Recommendation Report for Planning Permission

REF NO: BE/107/18/PL

LOCATION: 42 Westfield
Bersted
PO22 9HF

PROPOSAL: 1 No. attached dwelling.

PROPOSED ELEVATIONS

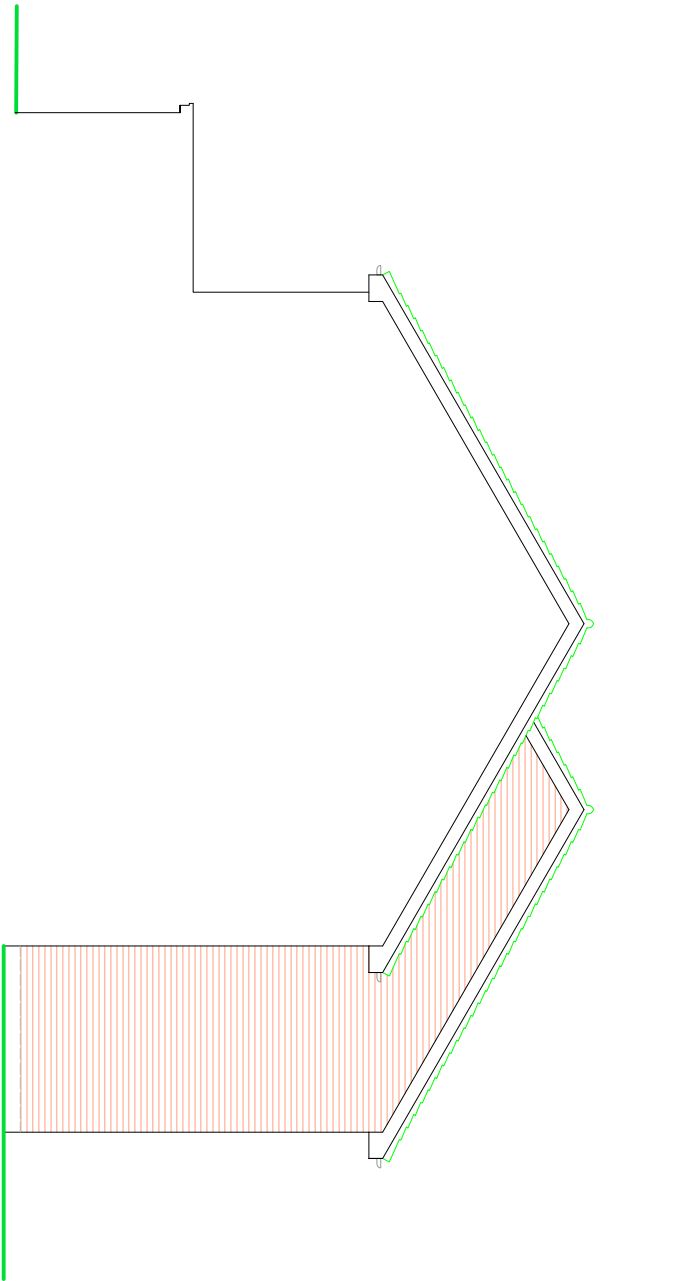
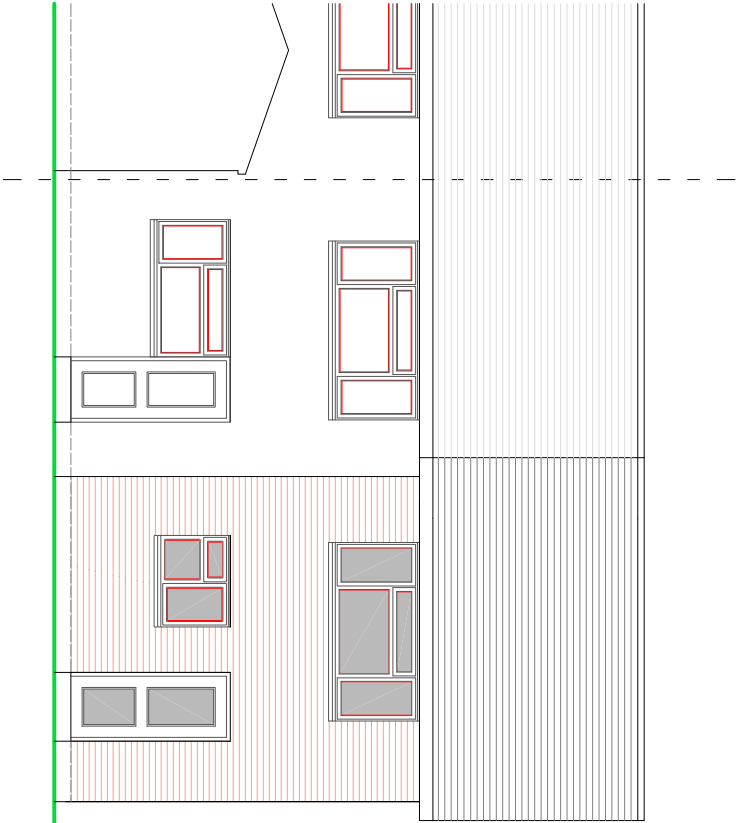
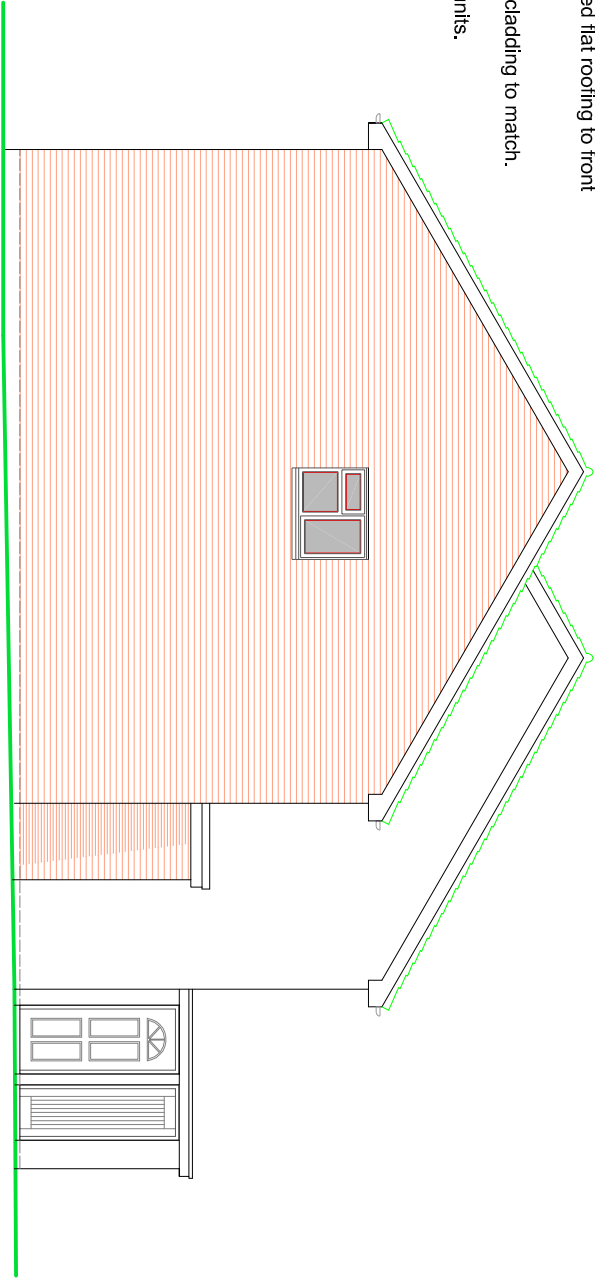
The proposal is for the erection of an end of terrace property on a corner plot adjoining 42 Westfield. Officers note that when viewed from directly opposite the front elevation the proposed new dwelling would appear to have a similar size, scale and massing to that of the other properties within the terrace.

The application site is a corner plot and that the proposed dwelling would bring the built form, side elevation of the terrace right up to the highway. As the site is a corner plot, consideration not only has to be given to the building line of the row of terraced properties it would adjoin but also the building line of the row of terraced properties to the rear. From an assessment of the plans and the Officer's site visit it was noted that the new dwelling would project significantly forward of the aforementioned building line of the row of terraced properties to the rear. Additionally, in order to accommodate 1 off-road parking space the proposed dwelling would be set back from the front elevation of adjoining property 42 Westfield, bringing the mass and bulk of the dwelling closer to the terrace of properties to the rear of the site. Therefore, it is considered that the proposal the proposal would appear as a prominent built form which would appear overbearing within the streetscene.

The proposed development by reason of its size, scale, massing and siting would have a detrimental impact on the streetscene and wider area and would represent overdevelopment of the site.

Officers note that the proposal would project past the rear elevation of adjoining property number 42 Westfield by 2.45 metres at 2 stories. It is considered that the proposal would have an impact on the amenity of the occupiers of adjoining property number 42 but it is not considered that the impact, with regard to overbearing effect, loss of light/sunlight, overshadowing and overlooking would be such that would warrant refusal.

SITE PLAN - 1/500

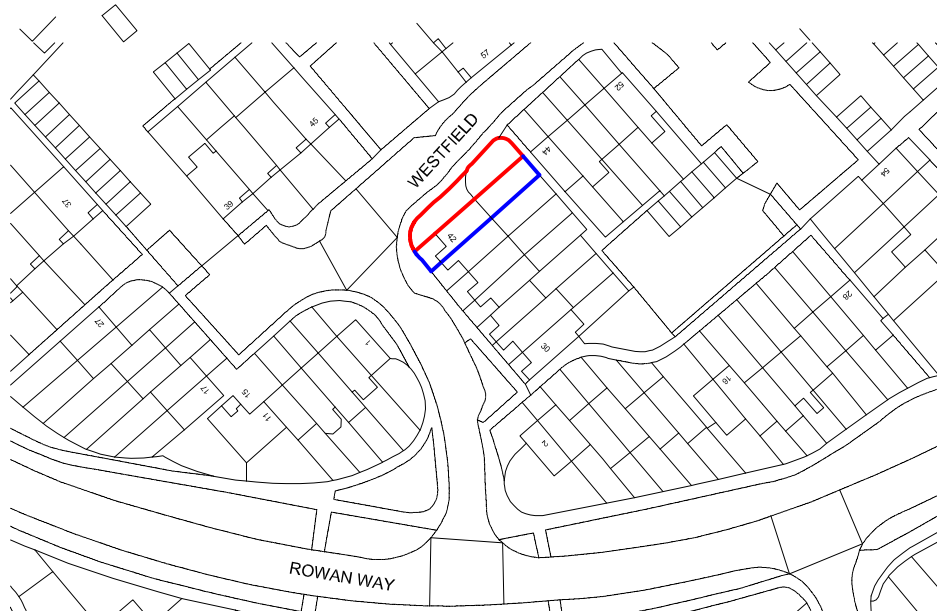
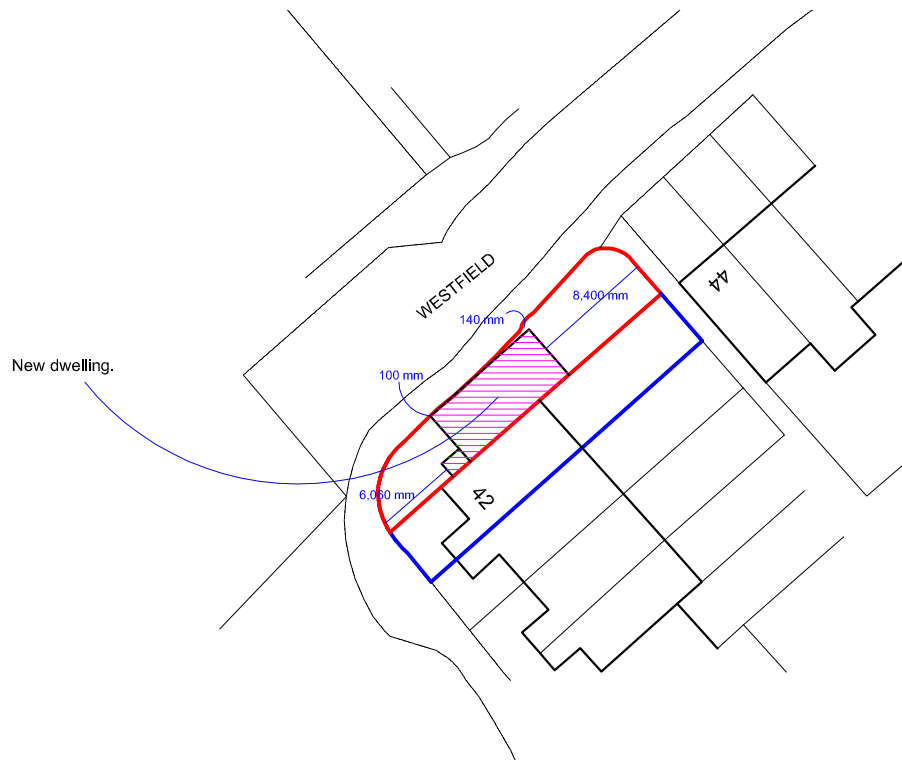
Currently, from an assesment of the submitted plans and the Officer's site visit it is considered that there is currently off-road parking provision for the parking of 2 vehicles on the hardstanding area to the side of the dwelling. From an assesment of the submitted plans and the application form proposed parking arrangement would provide 1 parking space for the new dwelling only. No parking is shown for the existing dwelling currently known as, 42 Westfield, Bersted.

From an assesment of the plans it is not considered that the proposed parking arrangement would not have an impact on highway safety or the amenity of the area. While there would be a shortfall of 1 parking space, Officers note that there appear to be no parking restrictions along Westfield and that while not ideal parking could be accommodated elsewhere.
